TfNSW Reference: SYD21/00574/04

DPIE Reference: SSD-18204994

**EXHIBITION OF EIS - EXHIBITION OF EIS - SNACK BRANDS MANUFACTURING
FACILITY - 14 & 2 DISTRIBUTION DRIVE, ORCHARD HILLS**

Attachement A

Notes:

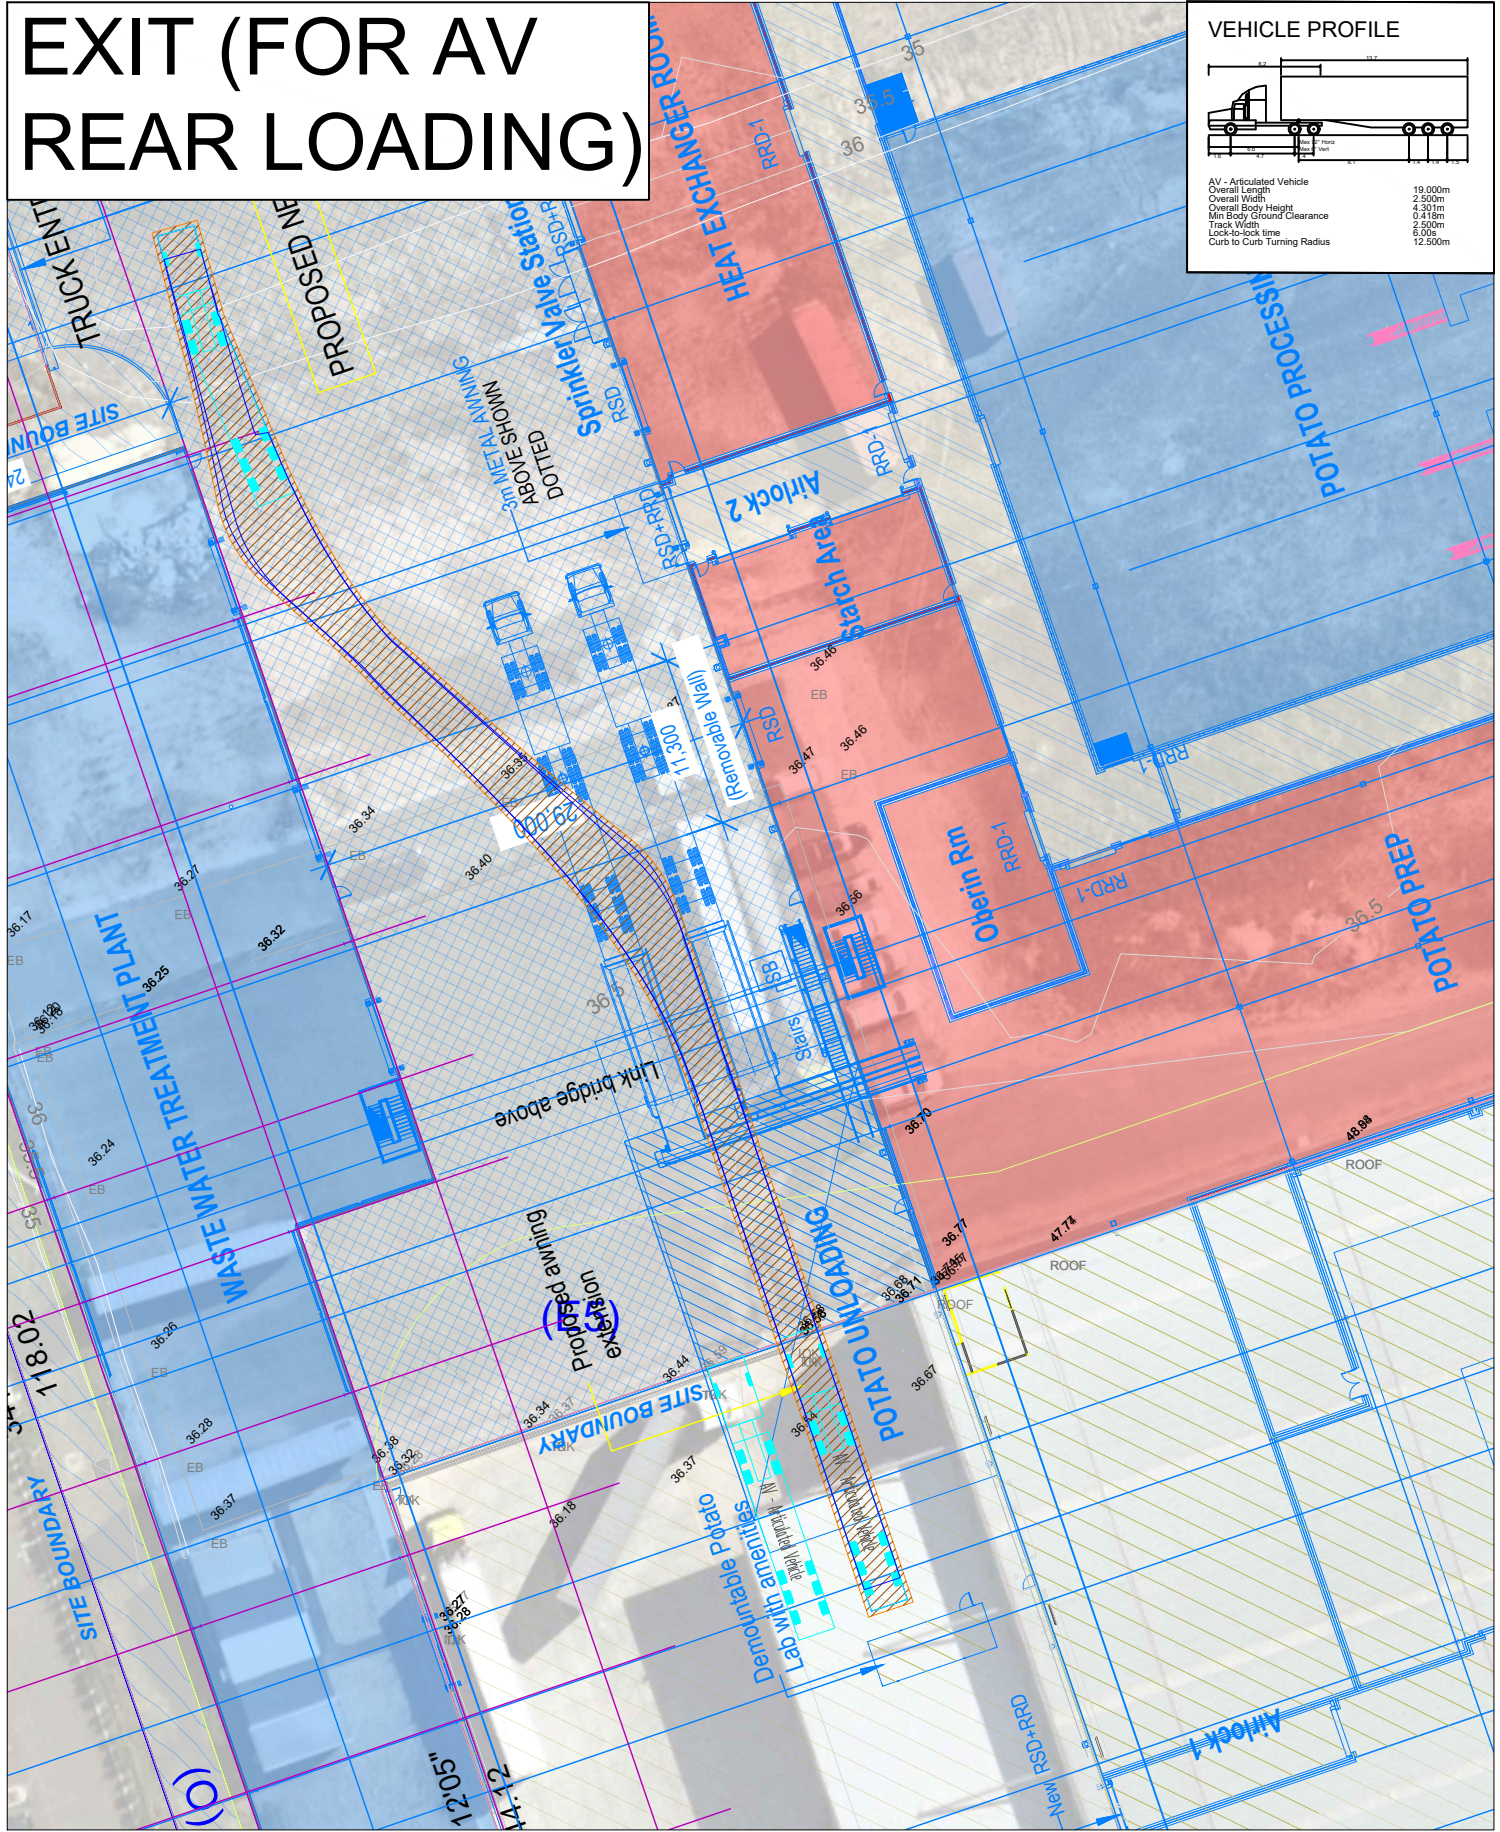
The TA has acknowledged two RSDs where B-doubles will be need to be reversed to unload from the rear. As the rear trailer is in the way, the front trailer (or A-trailer) of a B-double is typically unloaded by de-coupling the trailers, or jack-knifing the combination.

The TA needs to clarify whether a de-coupling area is required so that both the 'A' and 'B' trailers can be unloaded from the rear for the two RSDs which require B-double reverse movements.
